**Consultation Response from KC,  
Conservation & Design**

**2025/92713 Rear of, 23 to 43, Moor Lane, Gomersal, Cleckheaton, BD19 4LF**

**Reserved matters application pursuant to outline permission 2023/92079 for erection of residential development of 10 dwellings, demolition of existing extension at 27 Moor Lane, widening of existing access and realignment of boundary walls and discharge of details reserved by conditions 4 (noise), 5 (BEMP), 6 (Arboricultural Impact Assessment), 7 (safety and security), 8 (landscape), 9 (LEDS)**

**Date Responded: 24/12/25**

Tree Protection Plan to BS5837:2012 at:
Moor Lane, Gomersal

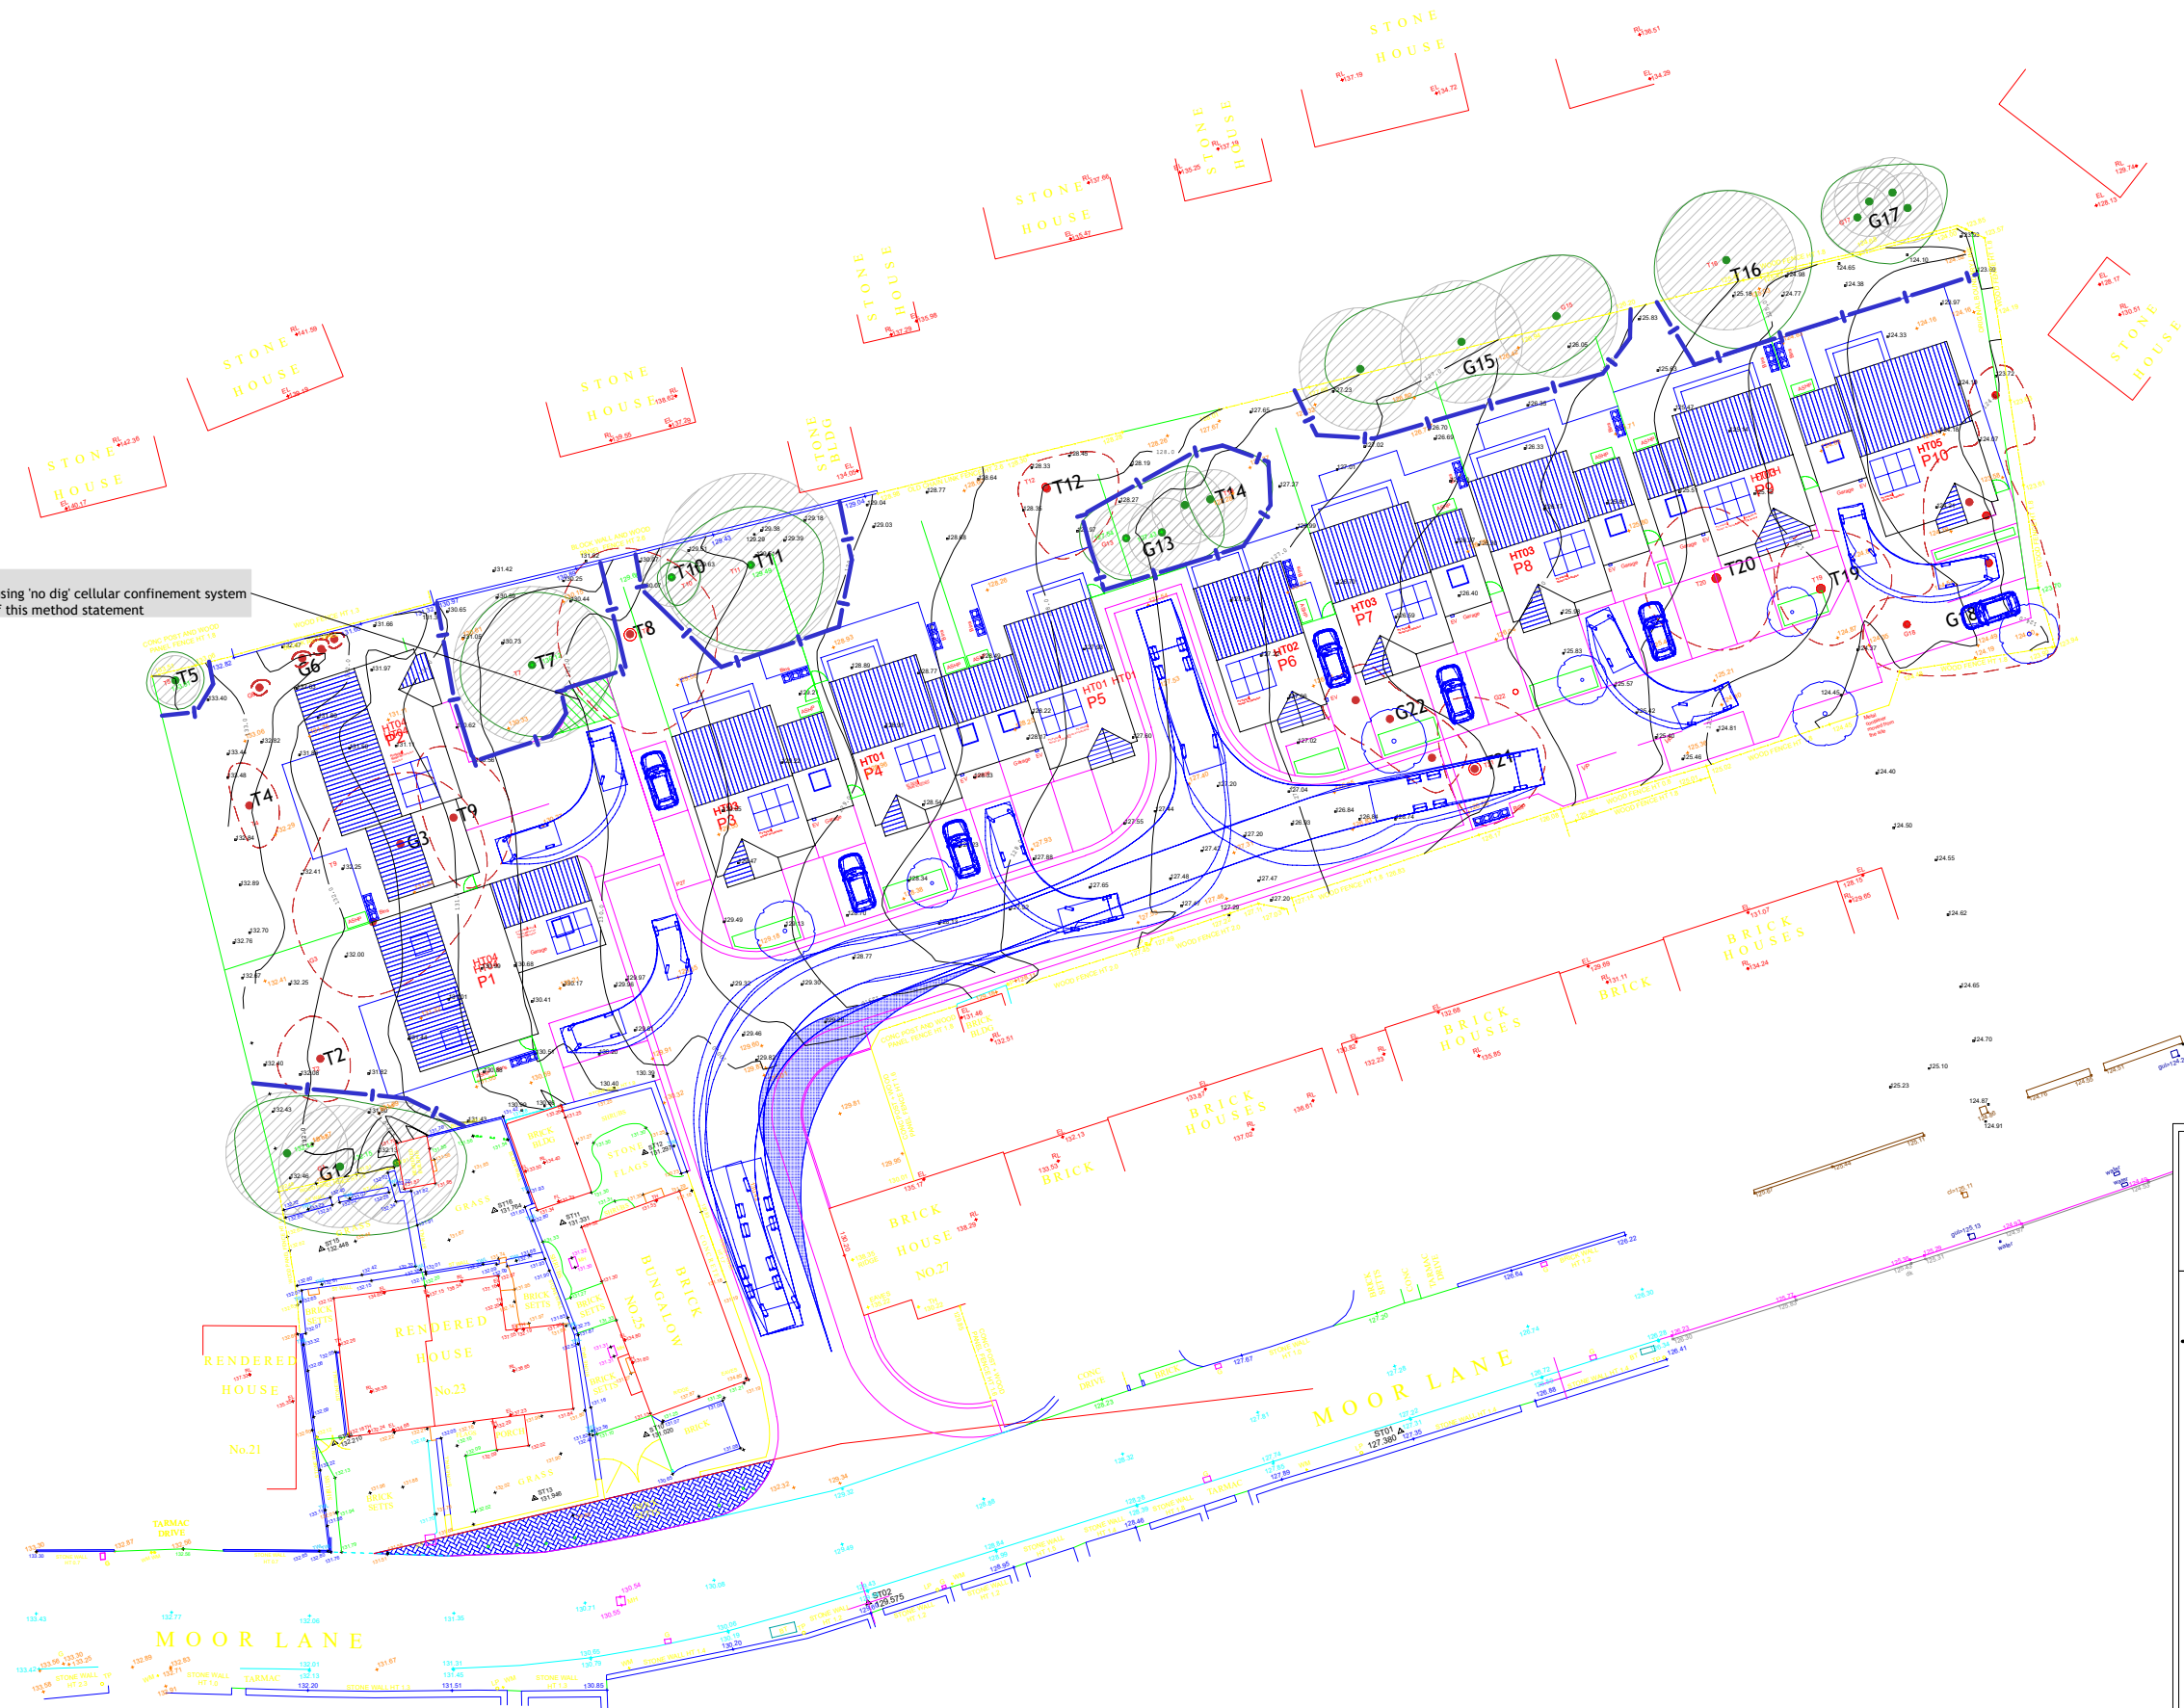
To the west of the site and within the conservation area is the Grade II\* listed Peel House, Manor House at 14 Knowles Lane, a mid-late 17th century manor house constructed in stone with some timber framing. There are concerns about the removal of trees on the west boundary. Retention of as many trees as possible on the west boundary would help to preserve the setting of the listed building.
